From: Nolan, Chris <Chris.Nolan@lancashire.gov.uk>
Sent: 06 September 2017 15:30
To: Robert Major; planning
Cc: LHS Customer Service
Subject: D3.2017.0744 - Lyme House Farm Thornley with Wheatley PR3 2TE
Attachments: 4971 - 04 Proposed Plan showing Passing Places.pdf

Applicant: E Roper and Sons
Planning Application No: 3/2017/0744
Grid Ref: 362280 440635
Proposal: Proposed cattle building.
Location: Lyme House Farm Thornley with Wheatley PR3 2TE

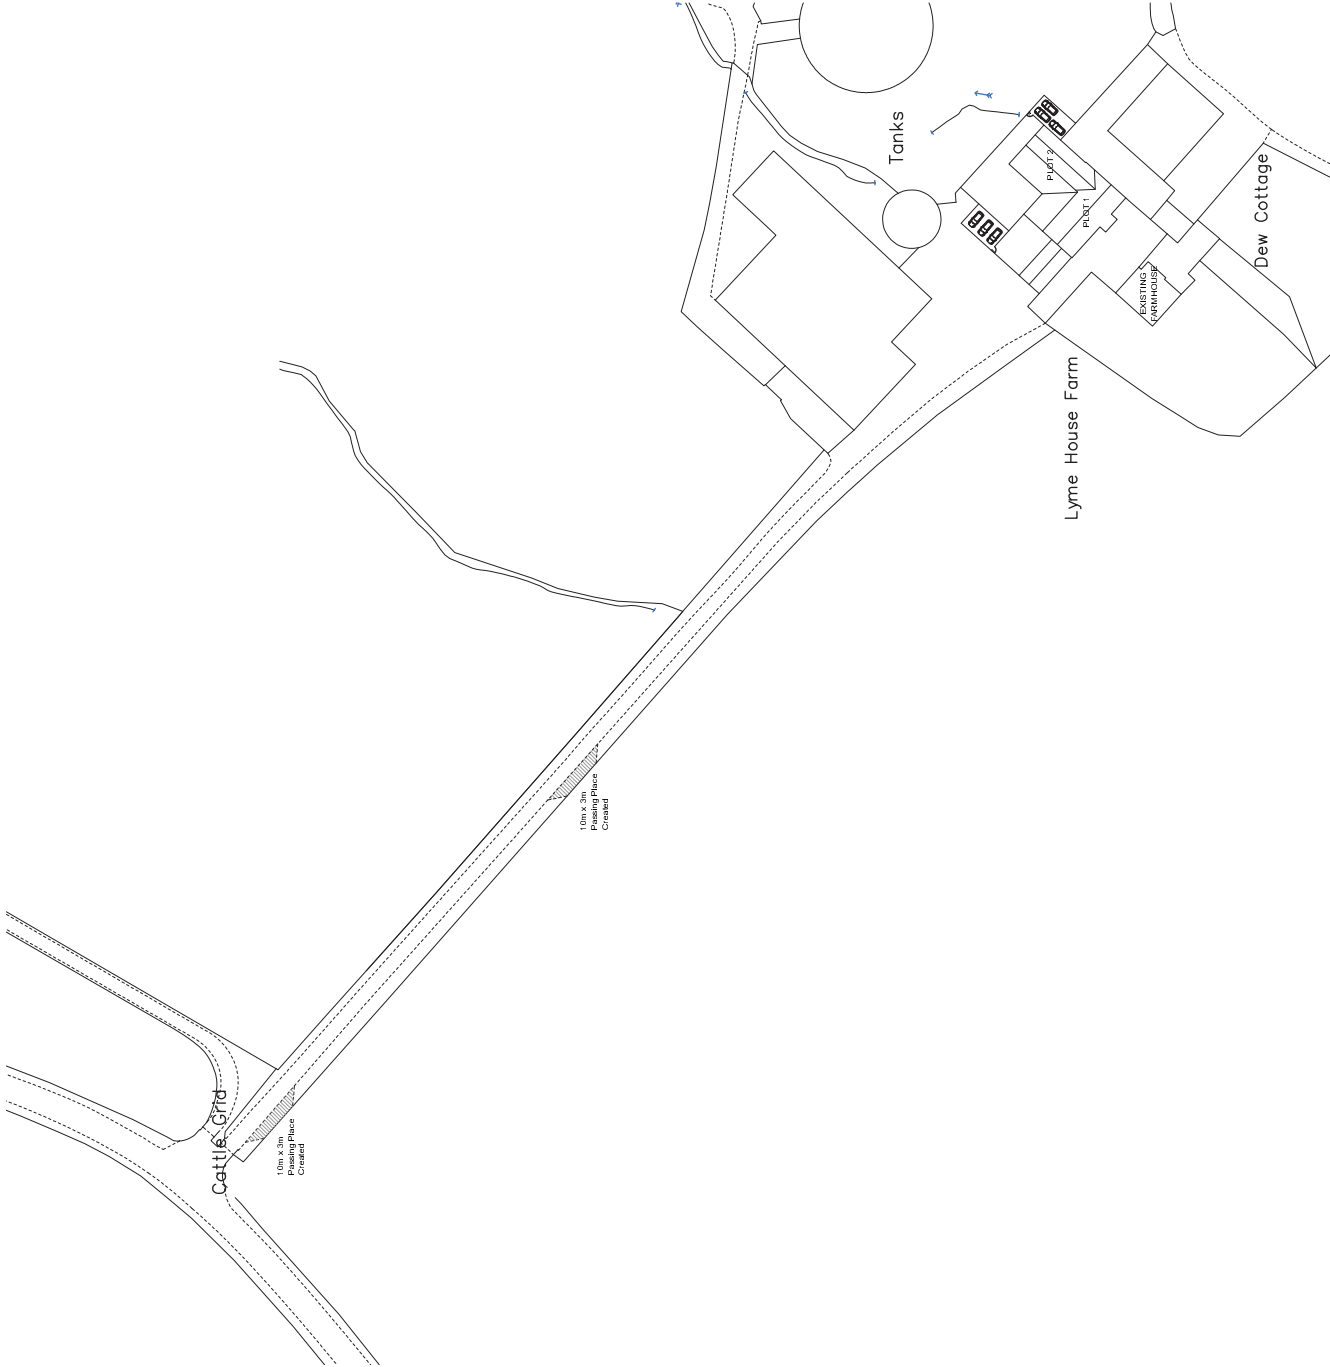
With regard to the above planning application for a cattle building. Whilst I would raise no objection to the proposal on highway grounds there have been a number of recent applications for this farm and all of these an increase in vehicle movements along the access road which has a restricted width and will not allow 2 vehicles to pass. I understand that my colleague as asked improvements to be completed to the access road prior to the development of two dwellings (App 3/2017/489). His request was for the formation of 2 passing places along the length capable of accommodating a tractor and trailer combination. These would be located within the site close to the site entrance and half way along the access. The attached plan, that I can confirm is in line with our requirements, was sent to us as part of the previous application. I would like to ensure that the work to produce the two passing places is completed prior to any further works on the site.

1. Prior to the commencement of any further development of the Lyme House Farm Site improvements should be completed to the access road to form two suitable passing places in line with the previously supplied drawing 4971-04. Reason : to ensure safe access to the site for residents employees and members of the public who wish to use the Public Right of Way.
2. For the full period of construction, facilities shall be available on site for the cleaning of the wheels of vehicles leaving the site and such equipment shall be used as necessary to prevent mud and stones being carried onto the highway. The roads adjacent to the site shall be mechanically swept as required during the full construction period. Reason; To prevent stones and mud being carried onto the public highway to the detriment of road safety.
